VARIATION OF CONDITIONS APPLICATION – LAND TO THE NORTH AND EAST OF WARREN MILL HOUSE, ELMSWELL ROAD, WETHERDEN

PERMISSION TO BE VARIED: DC/22/03101

CONDITIONS TO BE VARIED: 2, 5, 6, 7, 8, 9

DRAWING
PLOT 1 - PLANS & ELEVATIONS AS PROPOSED.

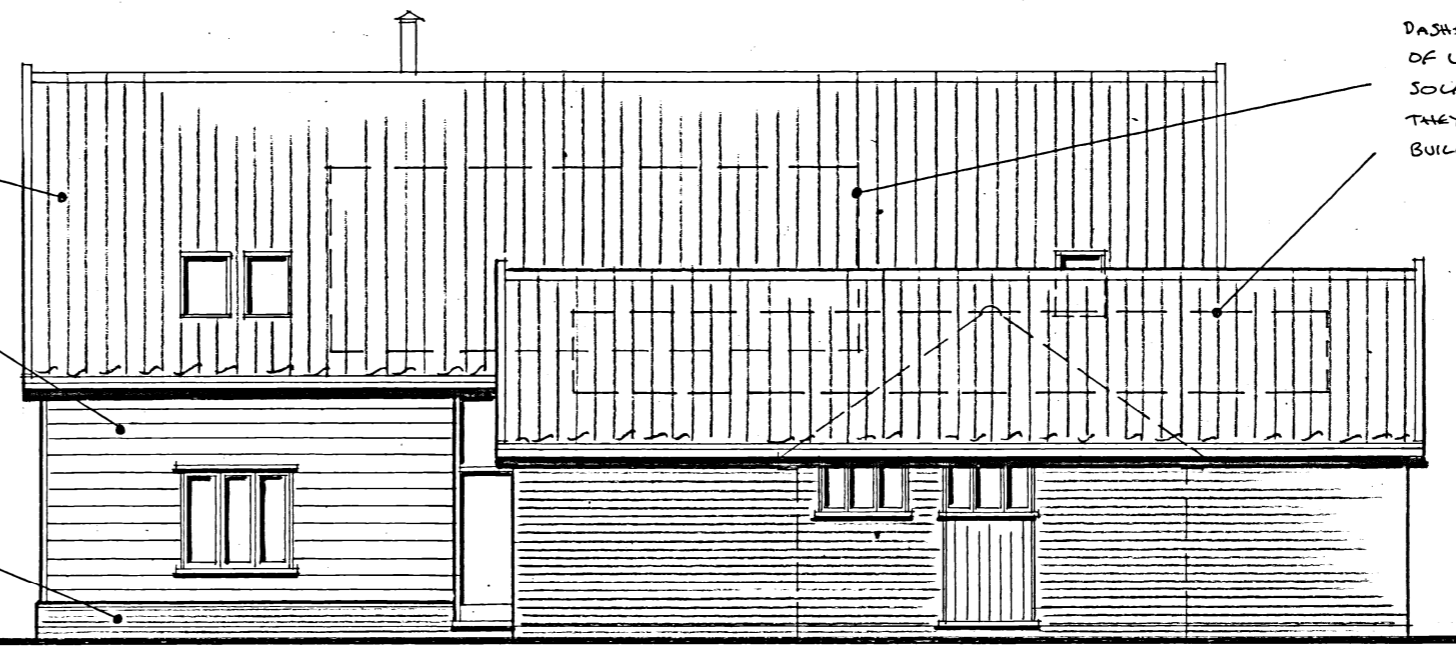
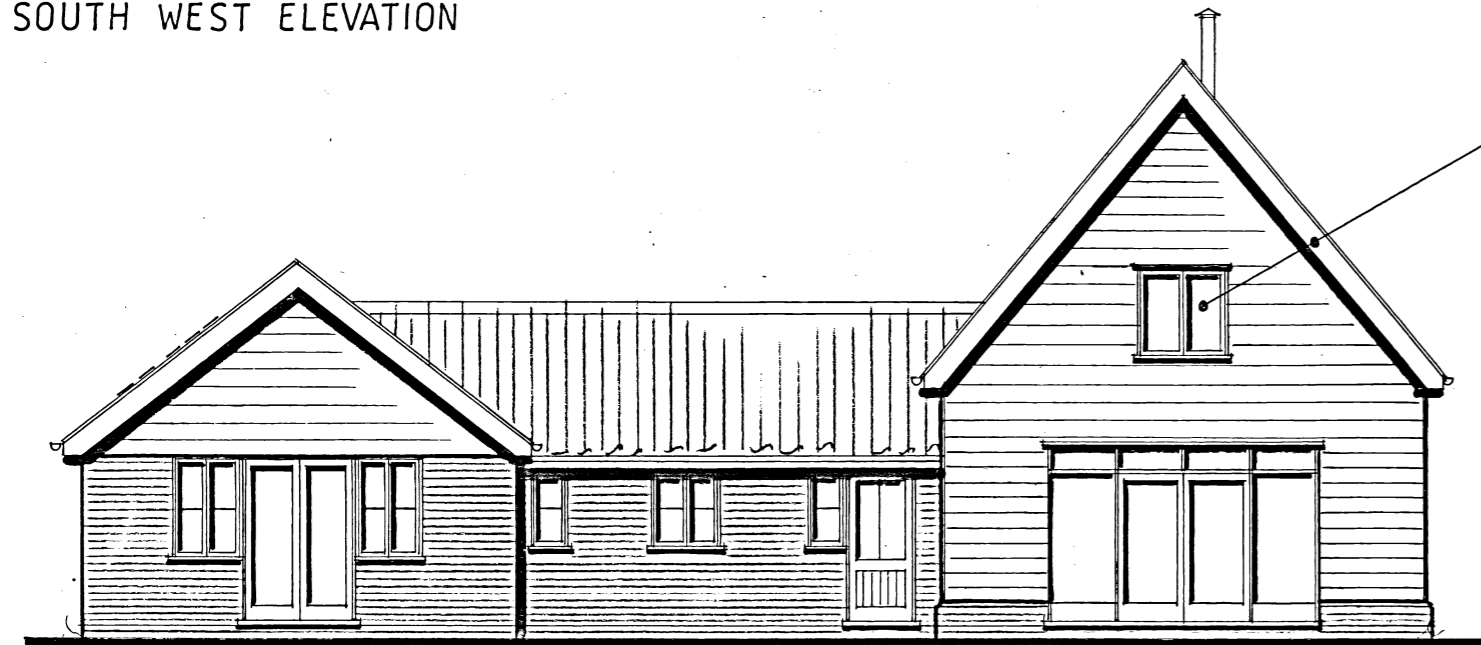
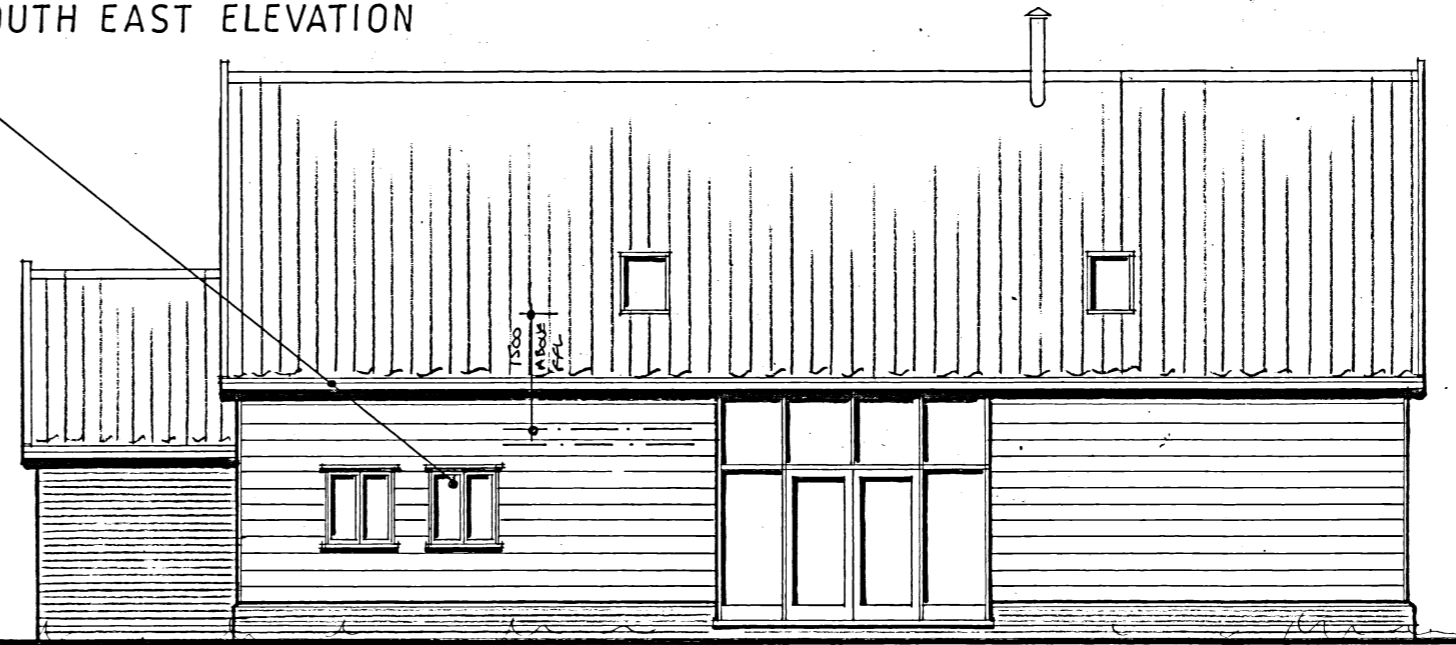
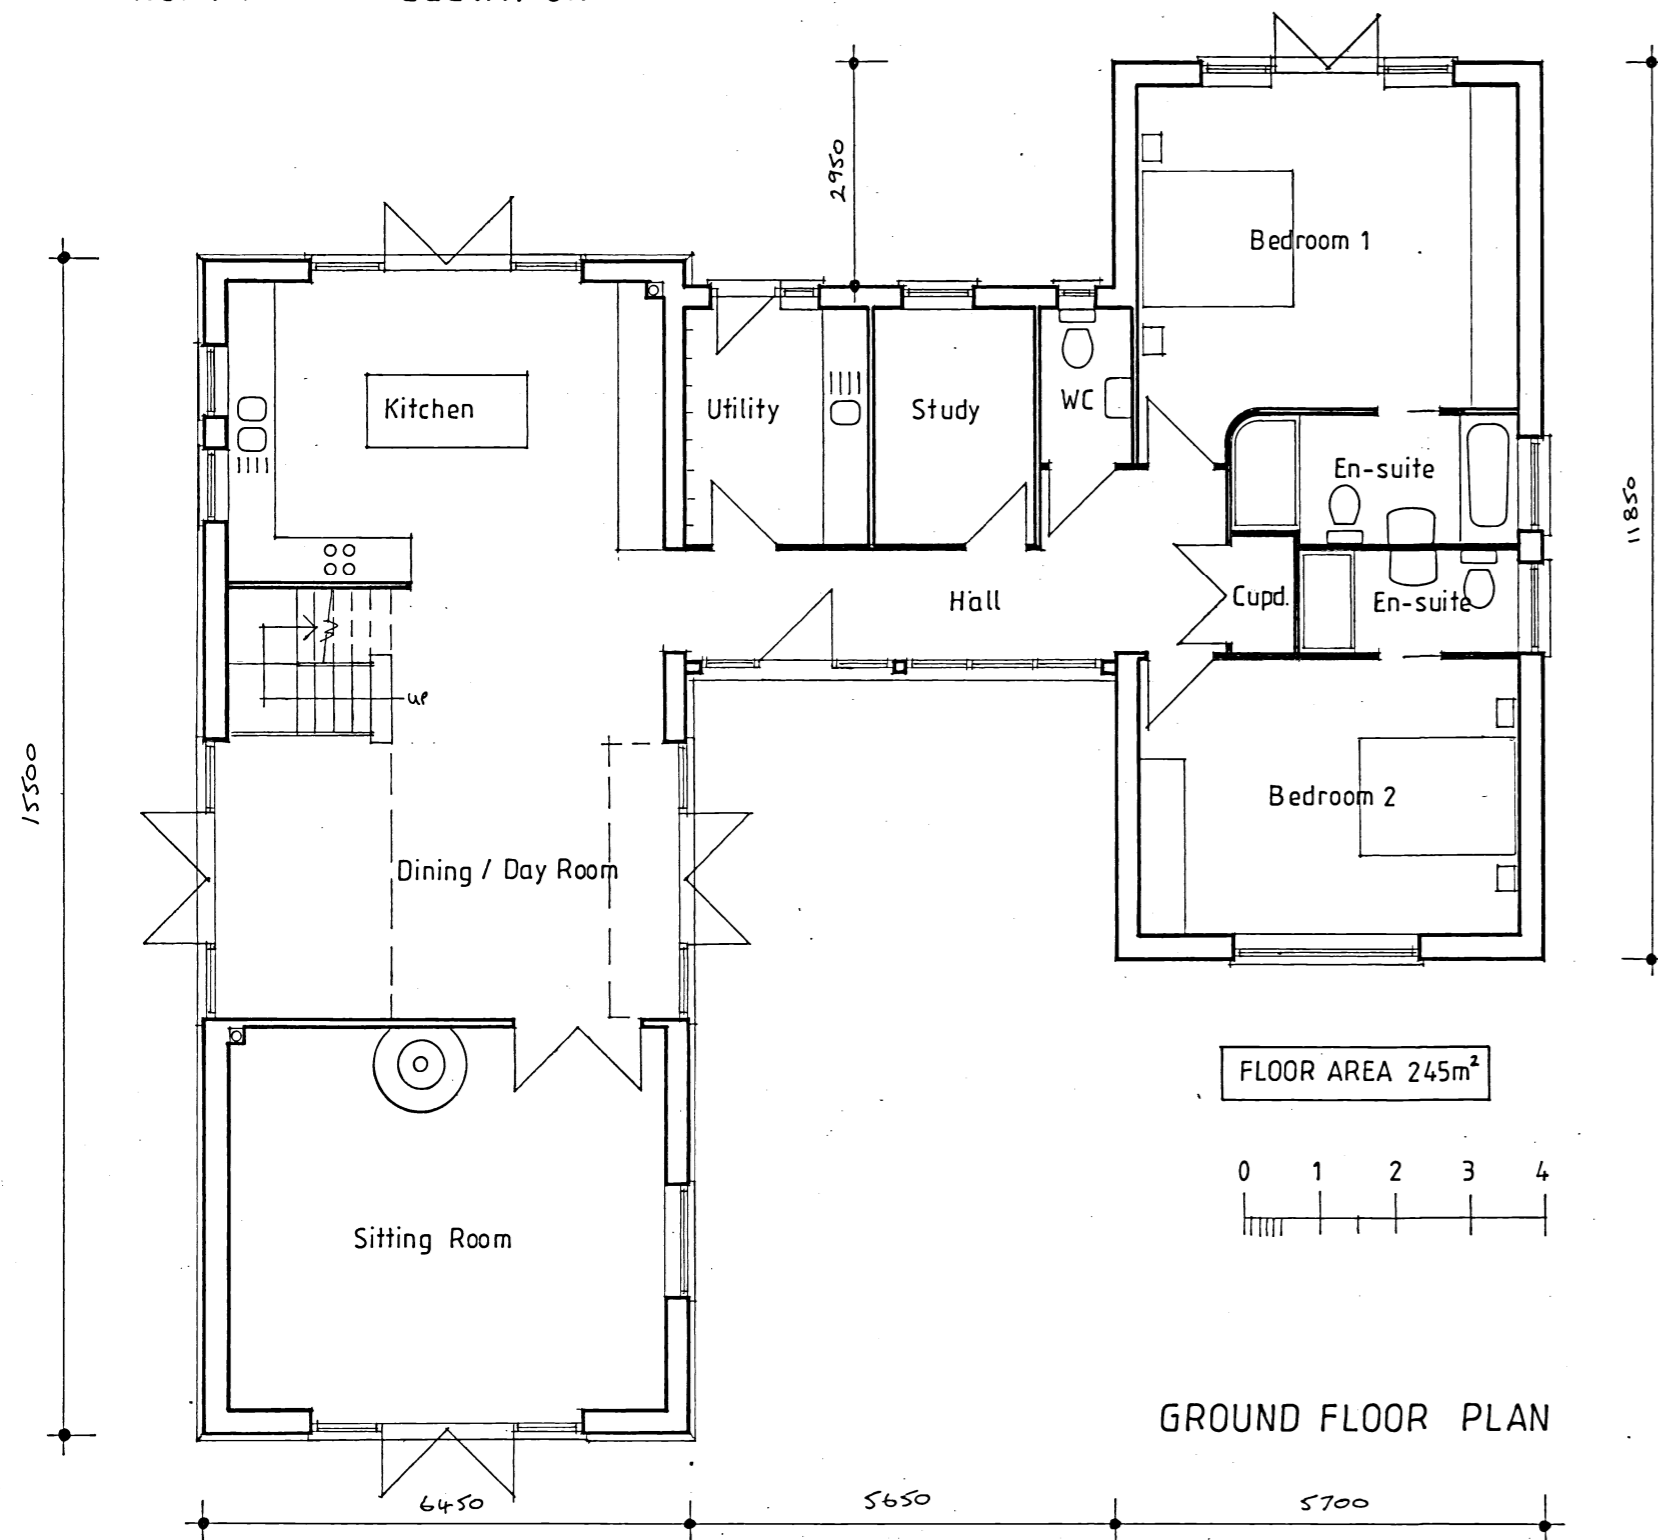
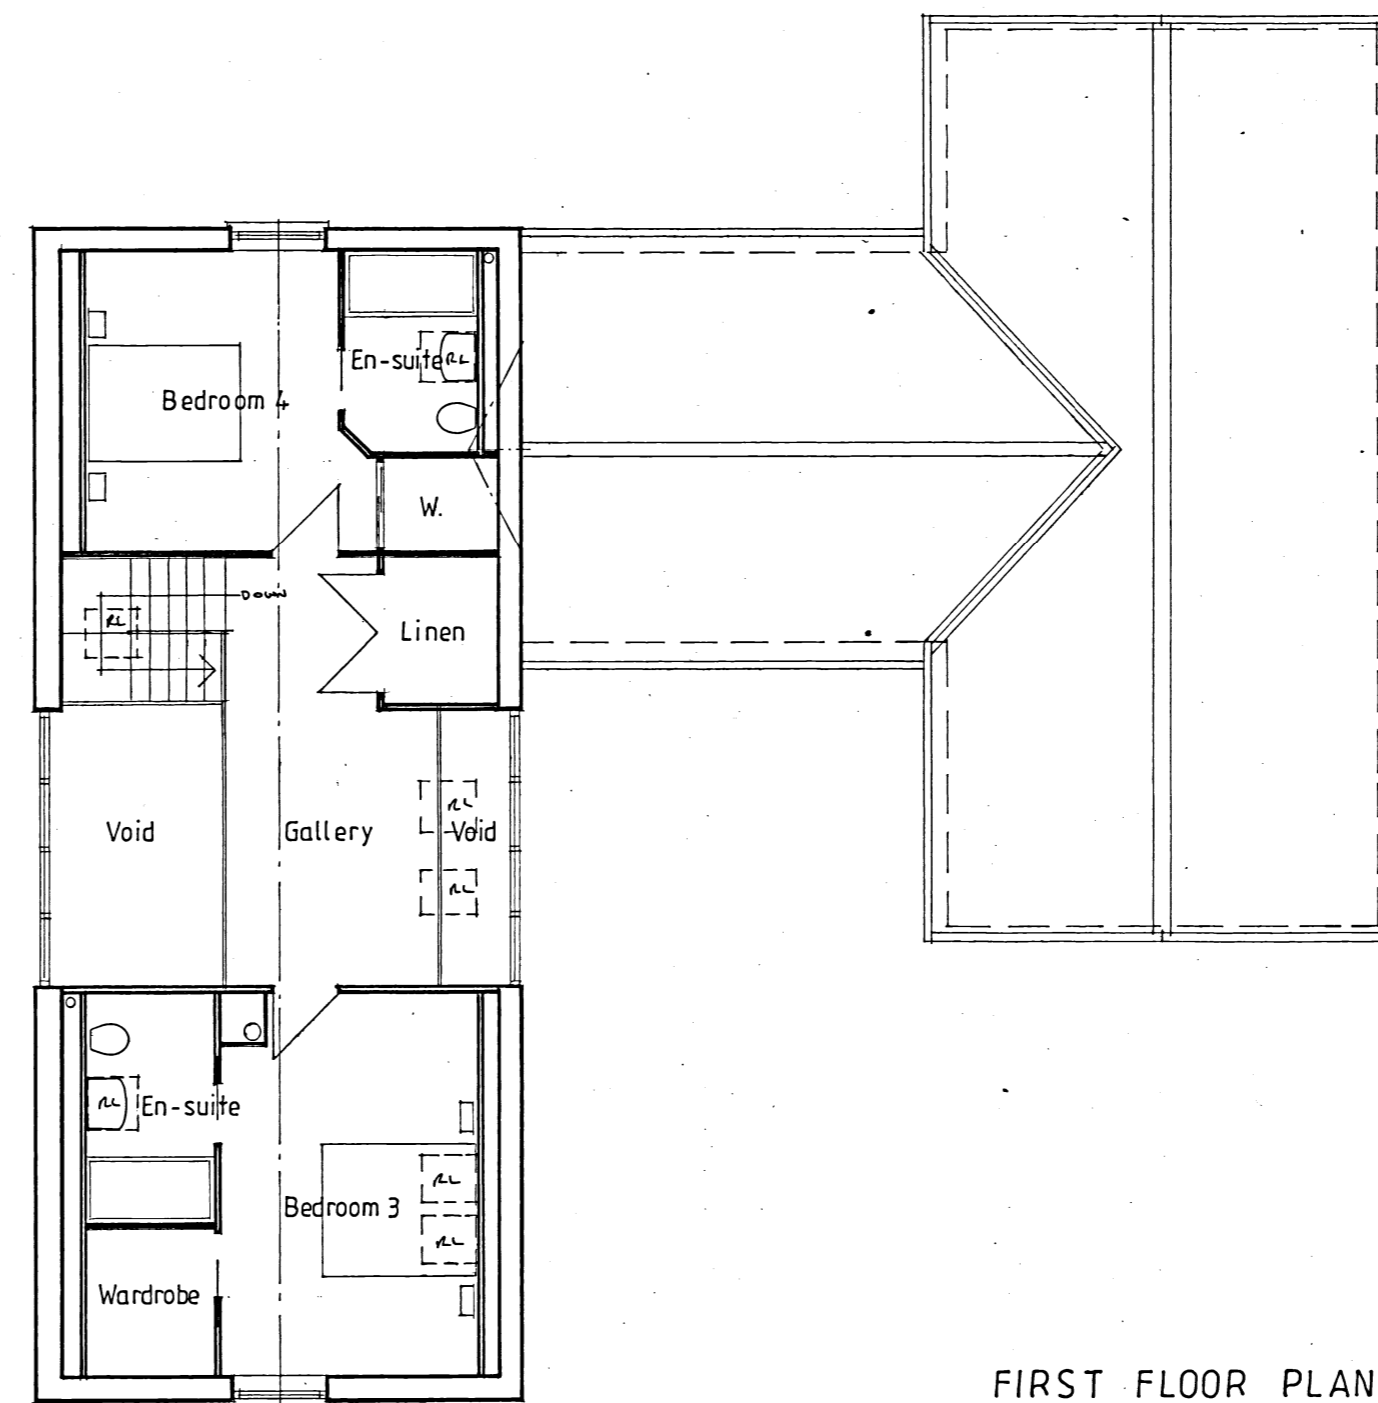
This variation seeks changes to the approved elevations and floor plans. The changes to the elevations of Plot 1 are minor and are mostly related to changes to the fenestration and the removal of the lean-to utility room element positioned to the north of the kitchen.

This variation application seeks to make changes to the internal layout of the Plot 1 house type and to make better use of the internal space of the houses. The roof space has been utilised to provide additional internal floor area to provide another bedroom. This increases the floor area while reducing the footprint of the building as the utility room lean-to element has been removed. The footprint of Plot 1 is reduced from 210 sqm to 200 sqm. The height of the roof has only been increased by 0.3 m to accommodate the additional headspace required. Plot 2 is proposed to mirror the updated Plot 1 design and is a handed version of this.
